CITY OF ALBUQUERQUE

**Re: McMahon Carwash
McMahon & Fineland
Traffic Circulation Layout
Engineer's/Architect's Stamp 11-18-19 (A11D016A)**

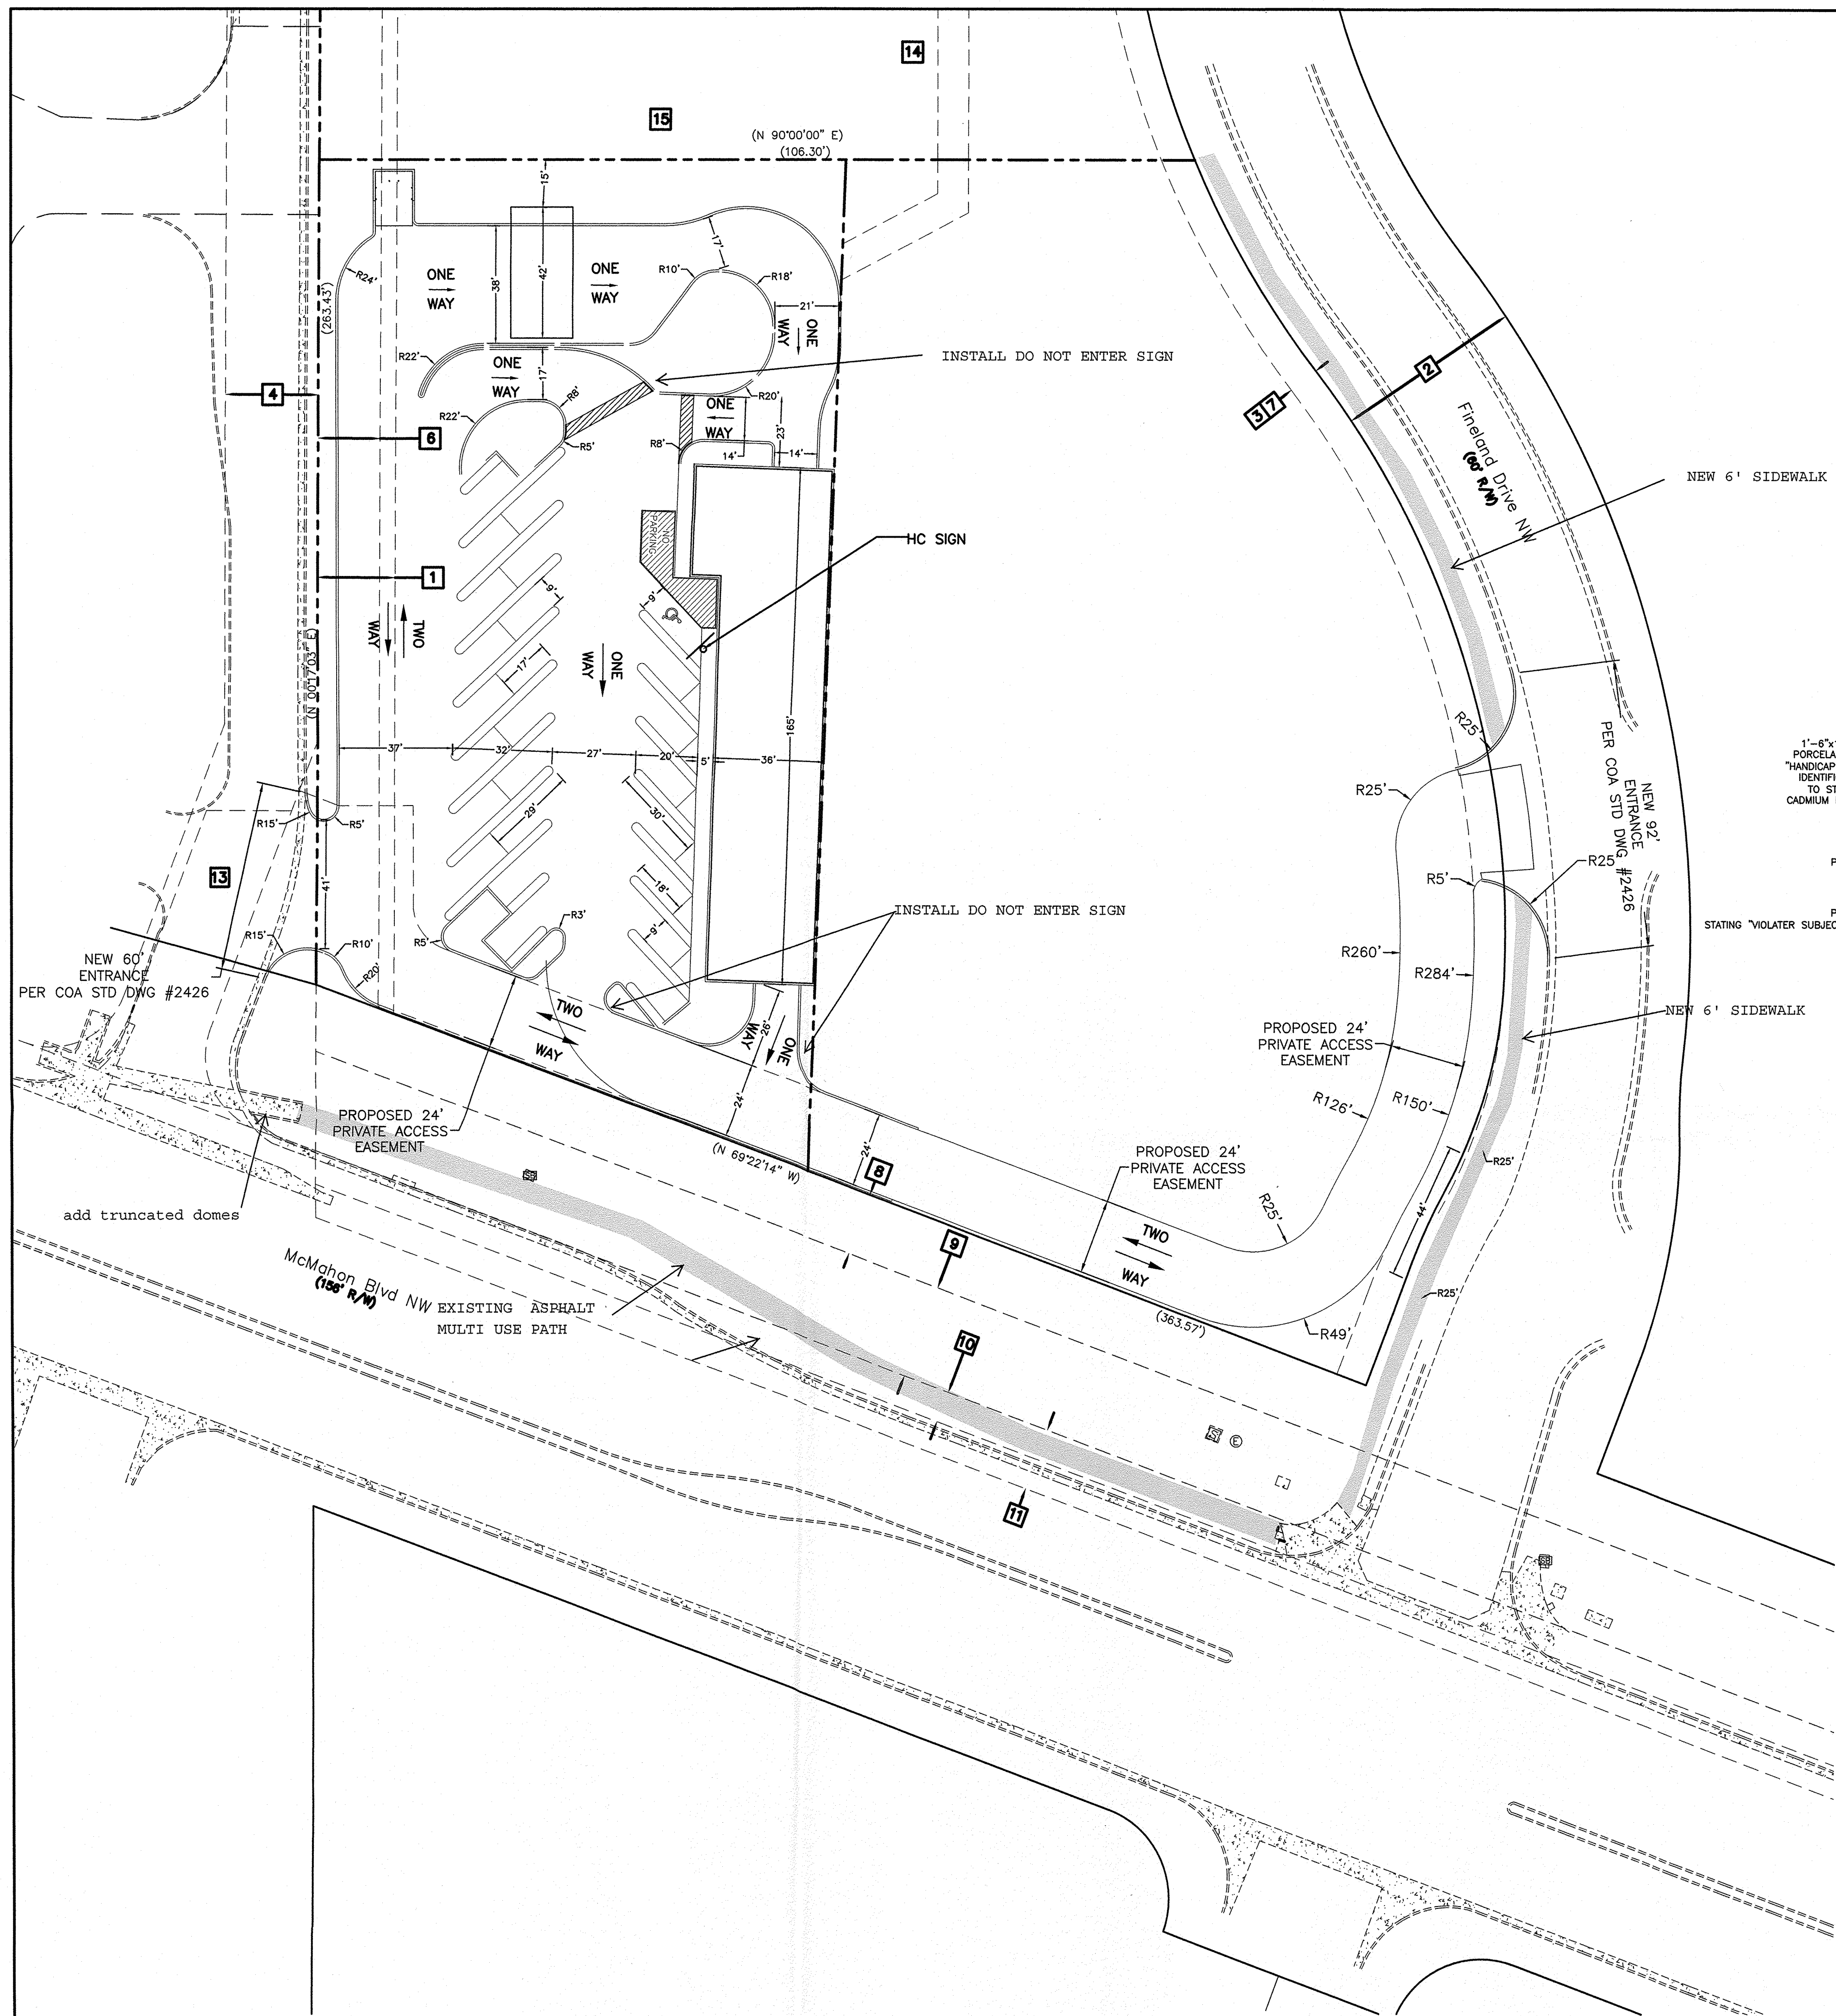
1. Identify all existing access easements. Please show all the key notes on the drawings.
2. Please list the width and length for all existing and proposed parking spaces. Some dimensions are not shown. For angled parking please follow the following table.

3. The ADA accessible spaces must include an access aisle. Van accessible aisles should be 8ft wide; all others should be 5ft wide.
4. The ADA access aisles shall have the words **"NO PARKING"** in capital letters, each of which shall be at least one foot high and at least two inches wide, placed at the rear of the parking space so as to be close to where an adjacent vehicle's rear tire would be placed. (66-1-4.1.B NMSA 1978)
5. Show all drive aisle widths and radii. Some dimensions are not shown.
6. Refuse vehicle maneuvering shall be contained on-site. The refuse vehicle shall not back into the public right of way.; provide a copy of refuse approval.

7. It is not apparent what type of pavement surface is being proposed. A hard driving surface will be required as part of this proposed project for parking area and drive aisles.
8. Show the clear sight triangle and add the following note to the plan:
"Landscaping and signage will not interfere with clear sight requirements. Therefore, signs, walls, trees, and shrubbery between 3 and 8 feet tall (as measured from the gutter pan) will not be acceptable in the clear sight triangle.
9. Shared Site acces: driveways that straddle property lines, or are entirely on one propertybut are to be used by another property, shall have an access easement. Please include a copy of your shared access agreement with the adjacent property owner.
